Phone: 0300 123 6780
Email: Kathryn.Walsh@lancashire.gov.uk
Your ref: 3/2025/0050
Our ref: 3/2025/0050/HDC/KW
Date: 06 March 2025

Location: 27 Wheatley Drive Longridge PR3 3TT
Proposal: Proposed reconstruction of two-storey, three bedroom house
Grid Ref: 360874 437803

Drg. No. **PL/002 Rev. B.**

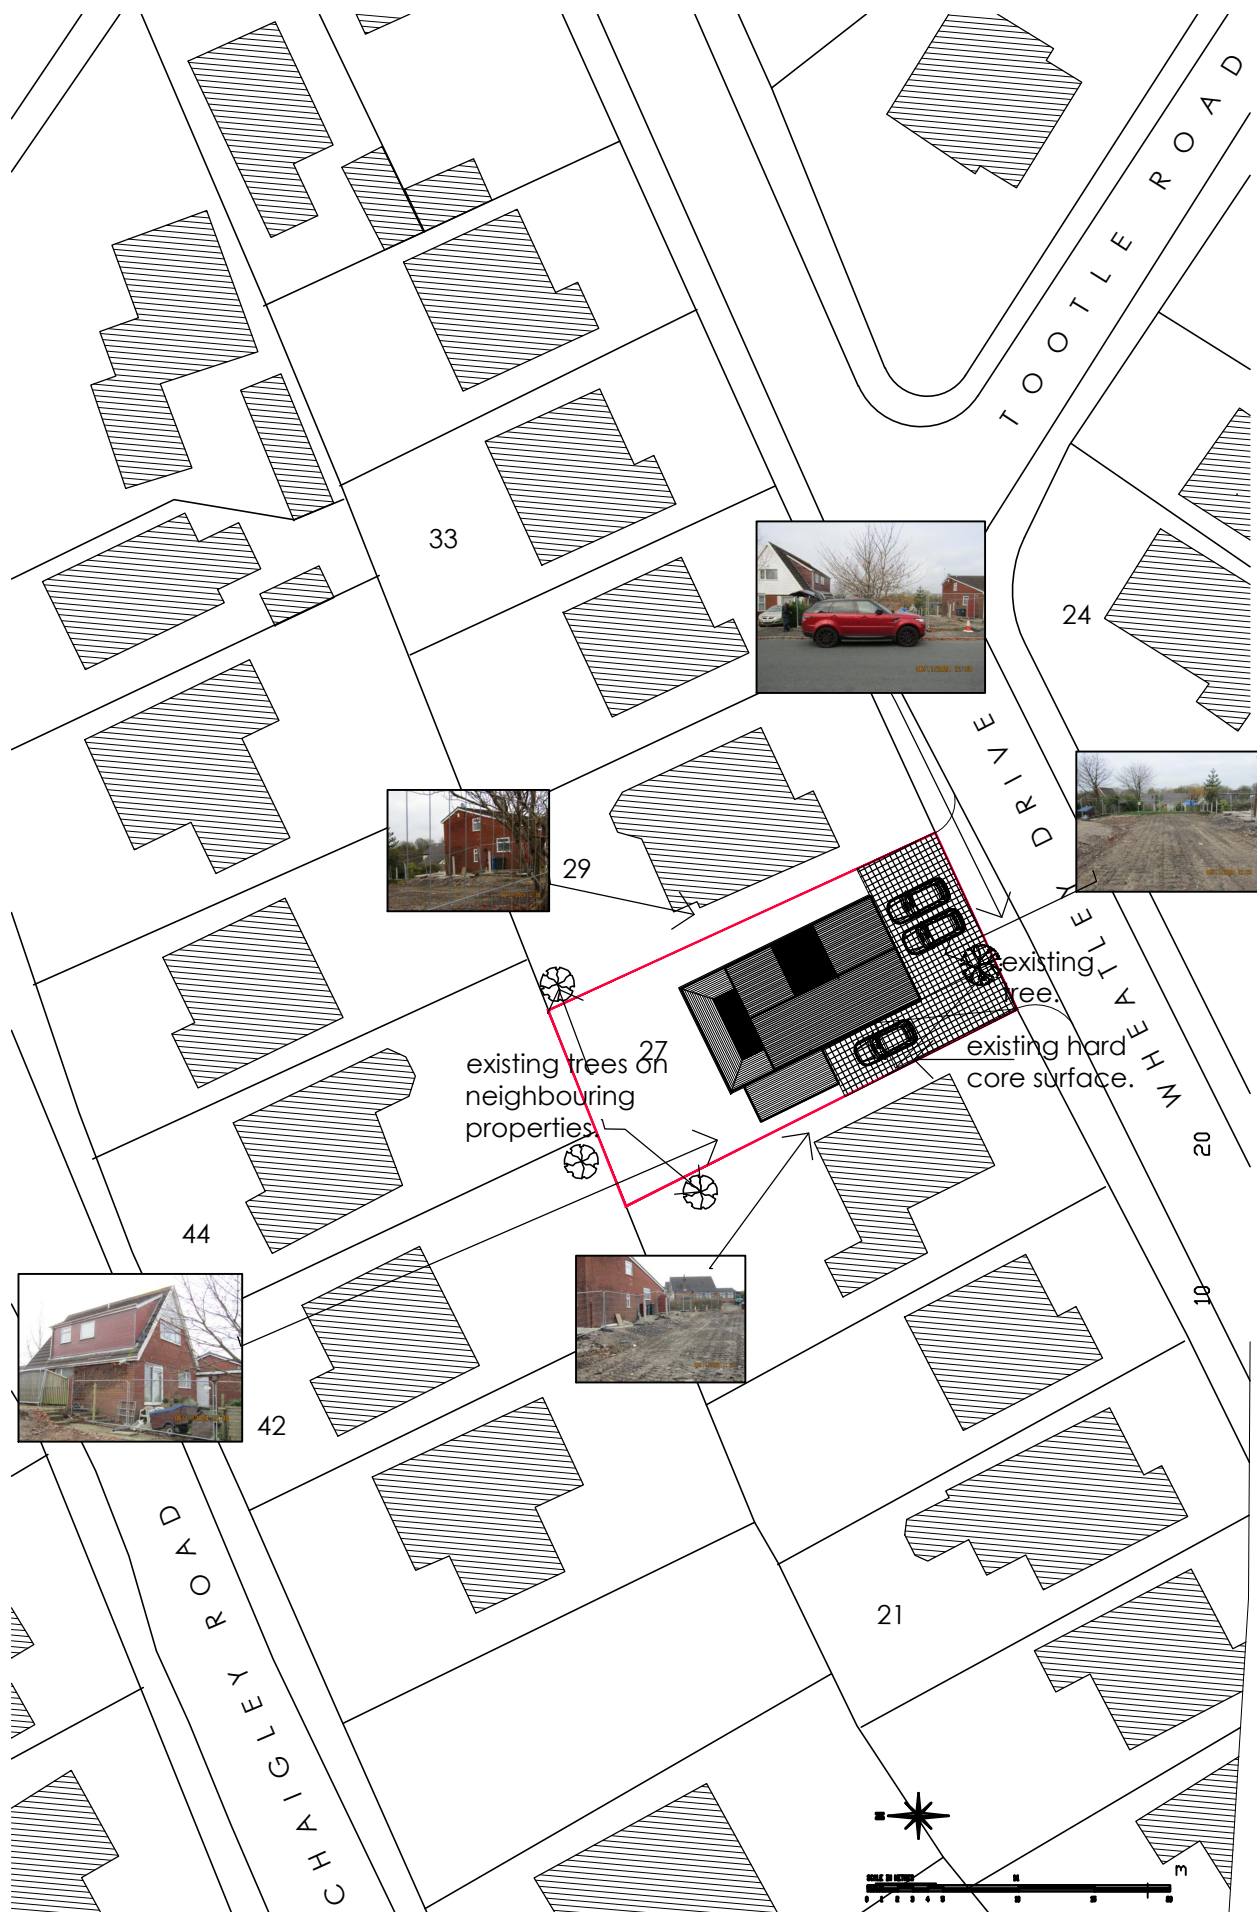
The LHA has reviewed drawing number PL/002 Rev. B. titled Location Plan and are aware that the dwelling complies with the LHAs parking standards as defined in the Joint Lancashire Structure Plan.

Scale: 1:50 1:100 @ A1.
Date: November 2024.
Format: AutoCAD 2022.
Drg. No. **PL/001. Rev. B.**

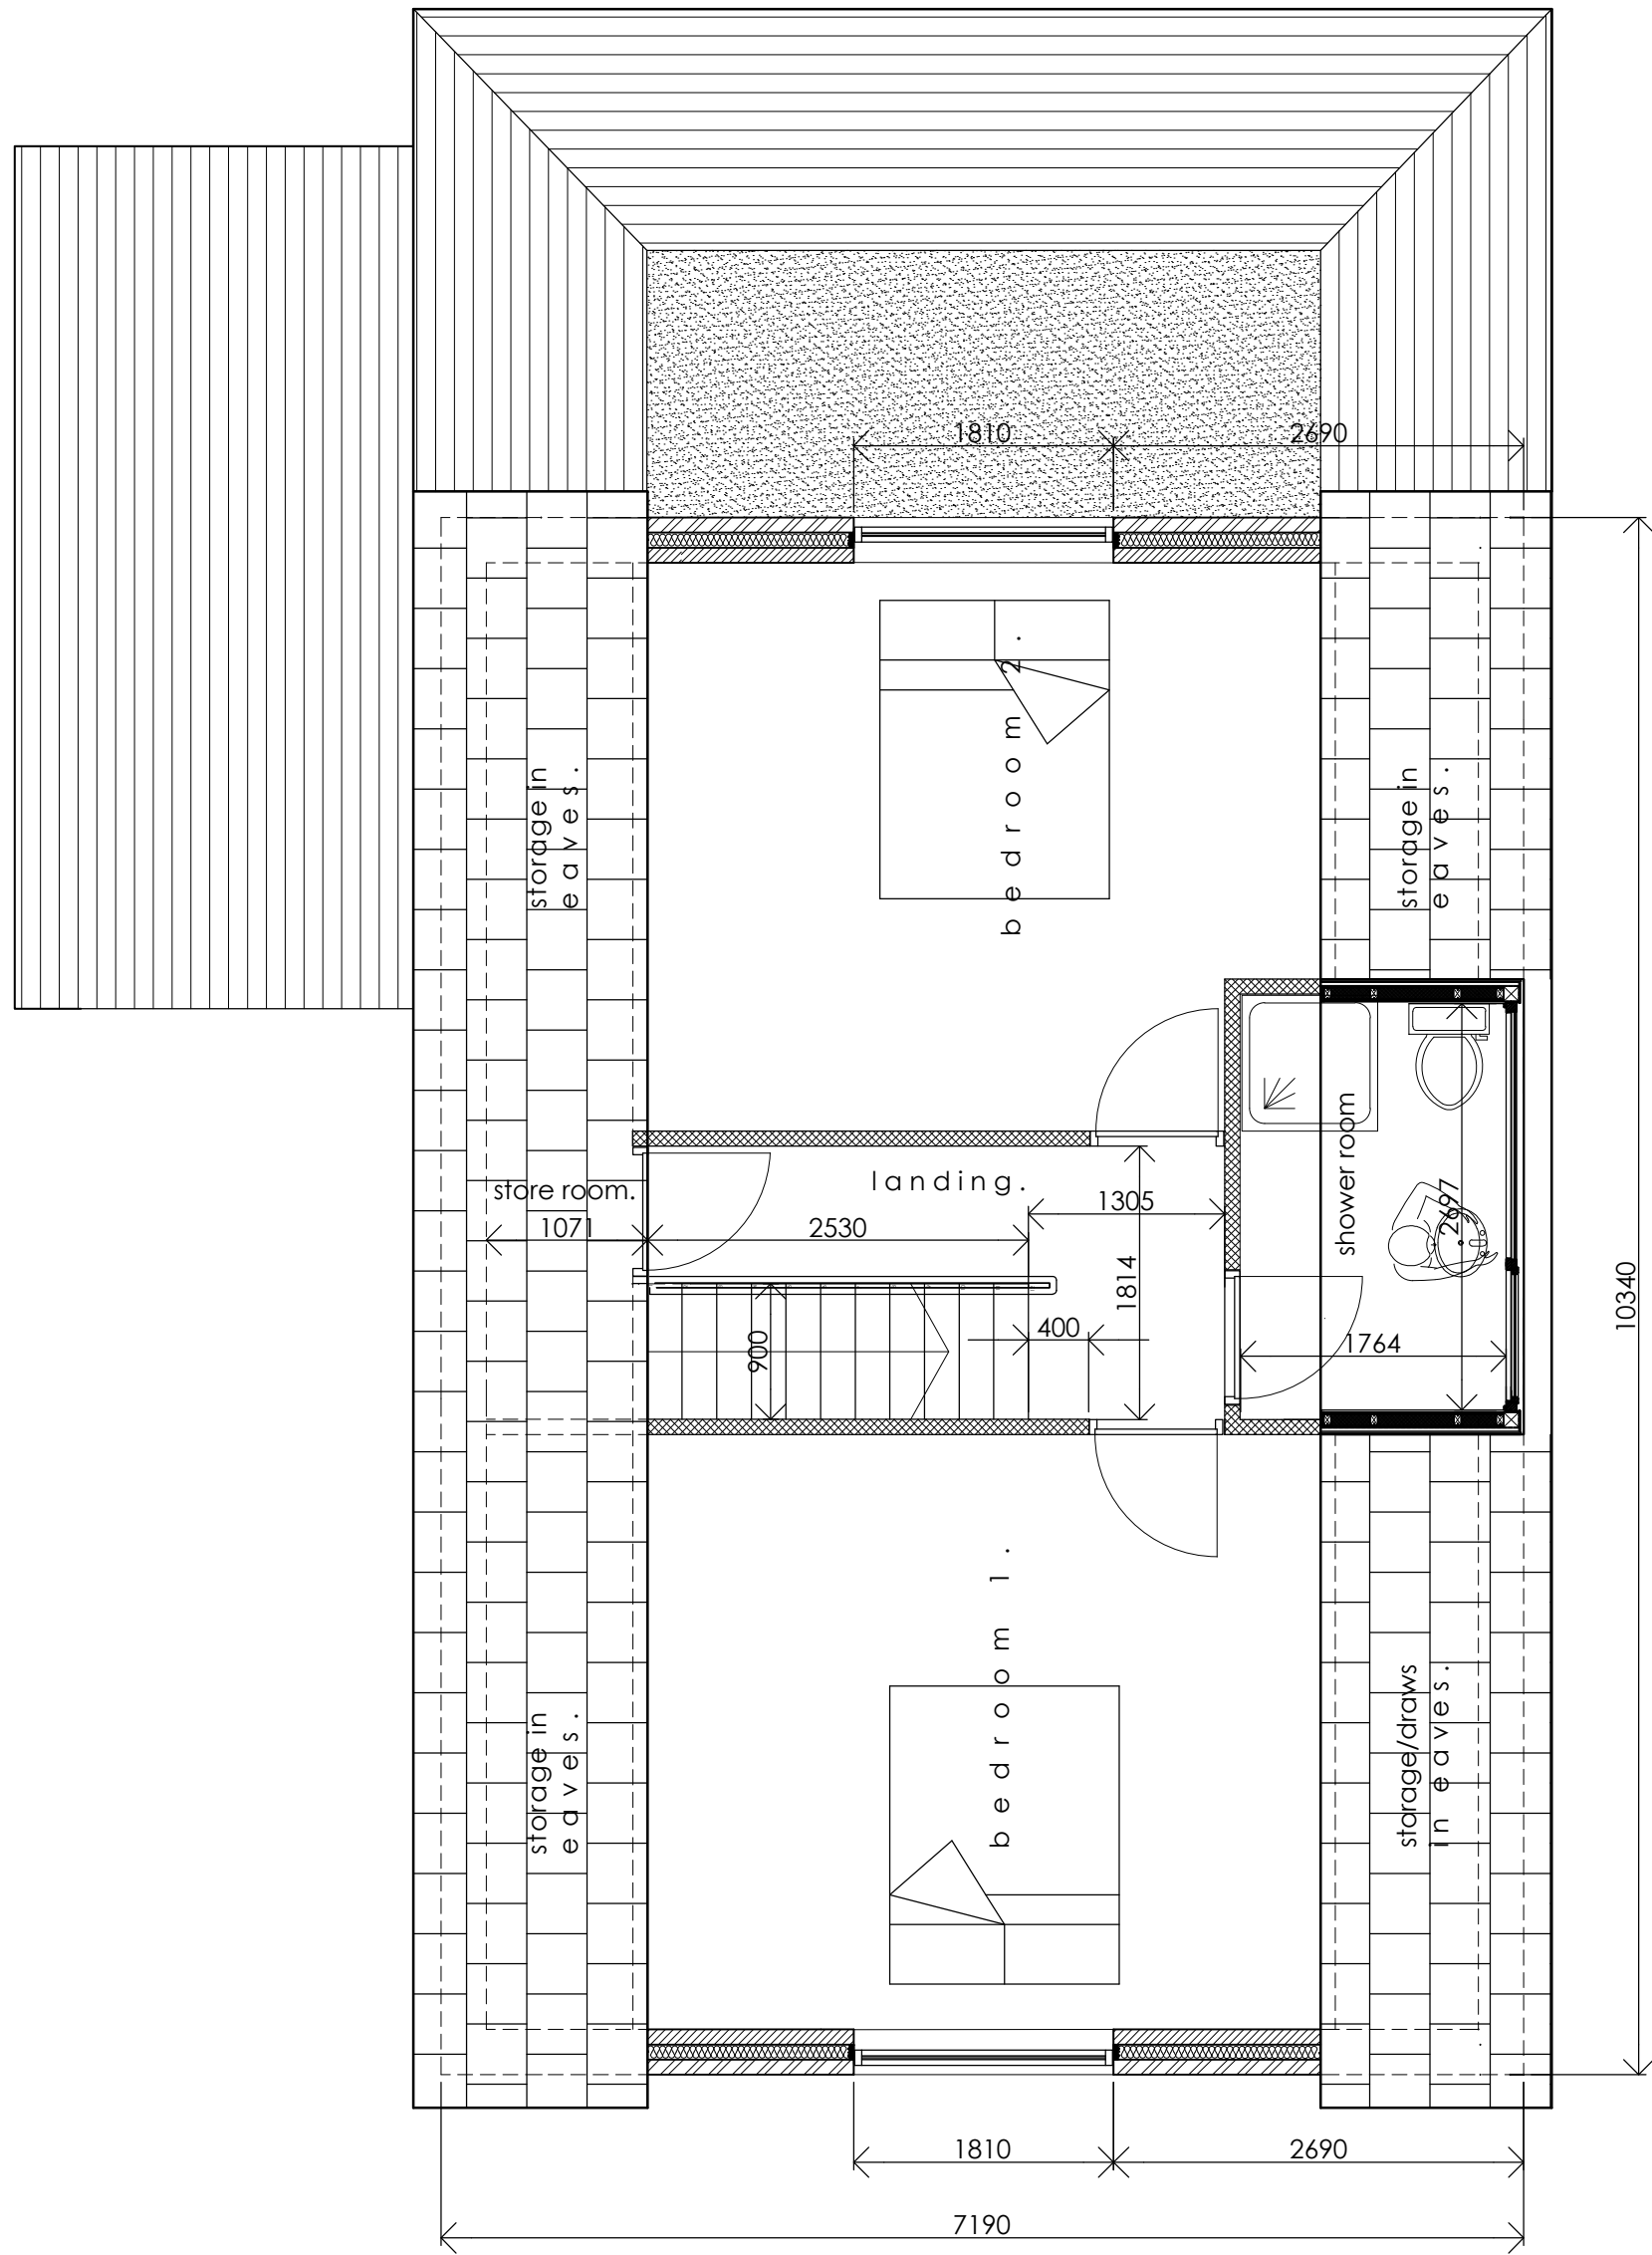
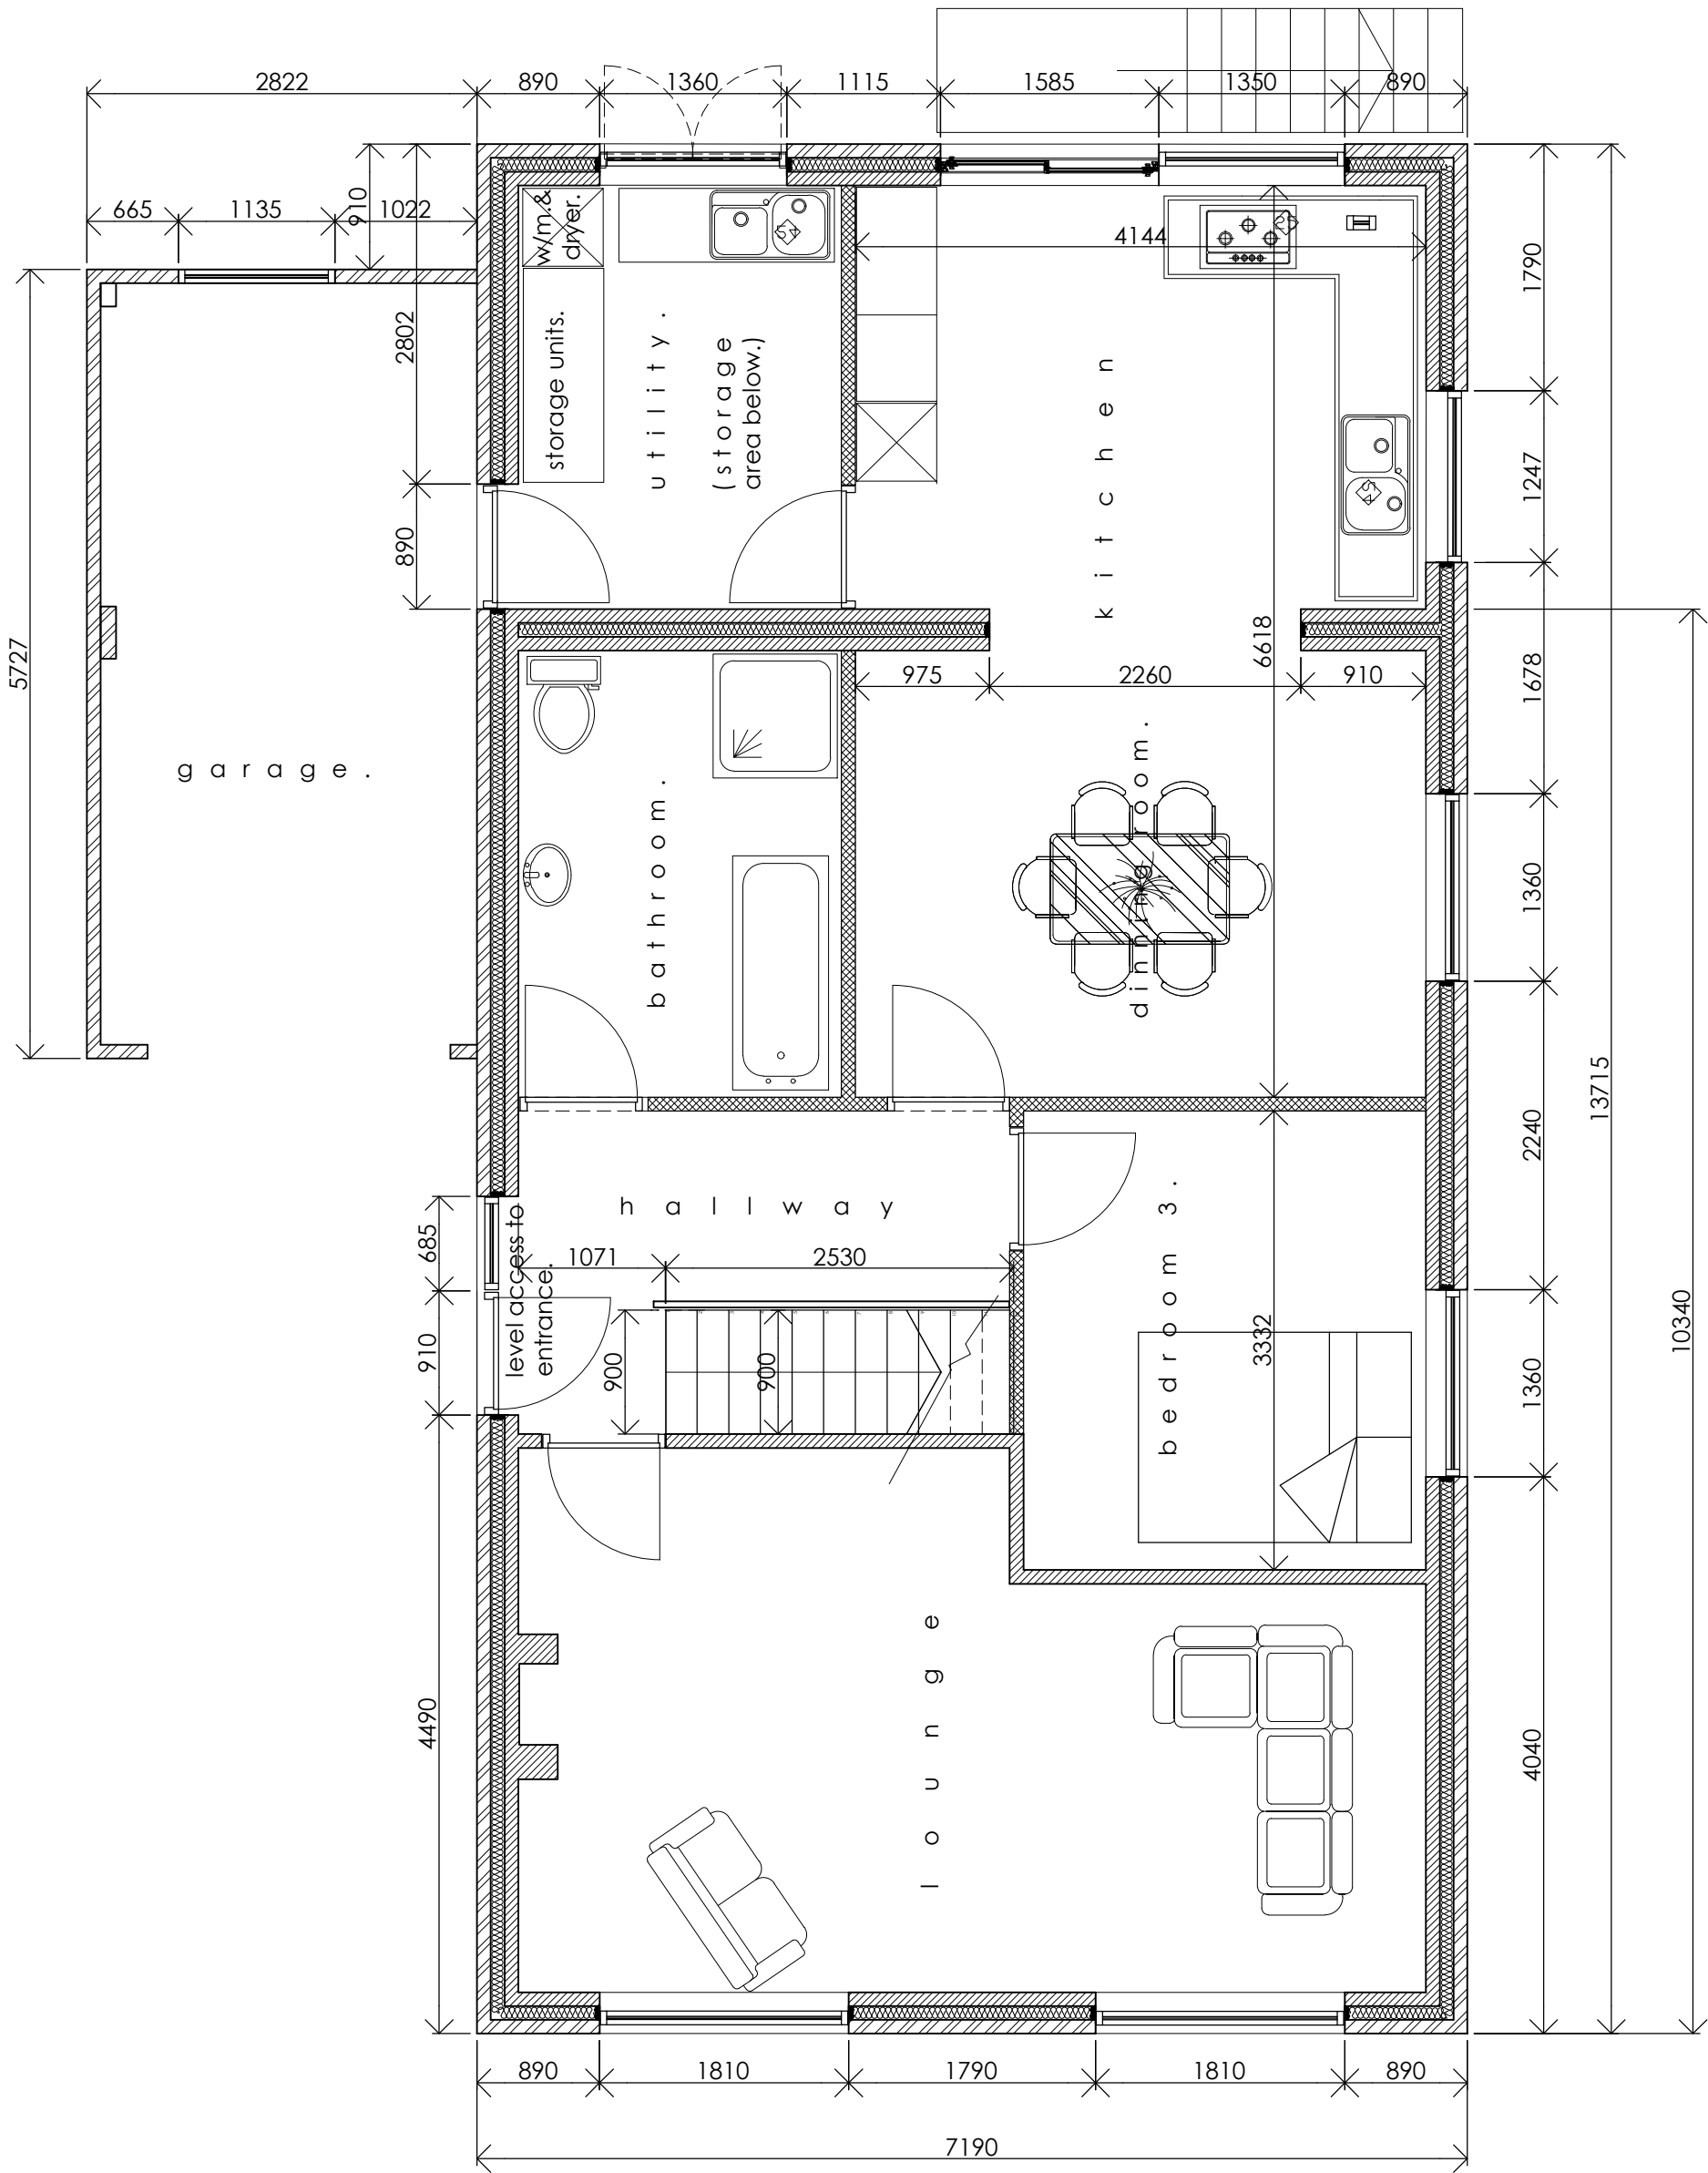
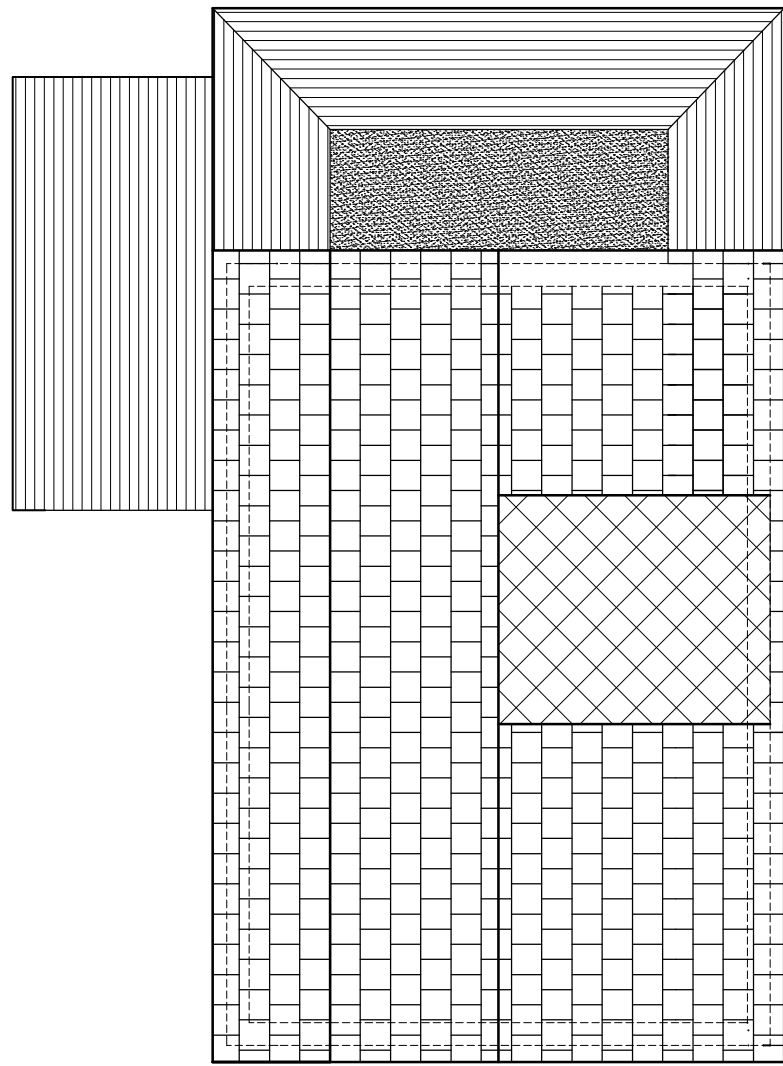
The LHA also reviewed drawing PL/001. Rev. B. and noted that the proposed garage does not meet the LHA recommended minimum internal dimensions for a single garage size which is 6m in length and 3m wide. The recommended distance of 6m is based on the length of a large family car (Ford Mondeo Estate 4.58m long), clearance at the rear of the car (200mm), overhang of the garage door (600mm) and room to stand in front of the car and open/close the garage door (600mm). Where garages are smaller than the recommended minimum internal dimension of 6 x 3m they should not be counted as a parking space. However, the driveway provisions support adequate parking provisions for the size and nature of the dwelling.
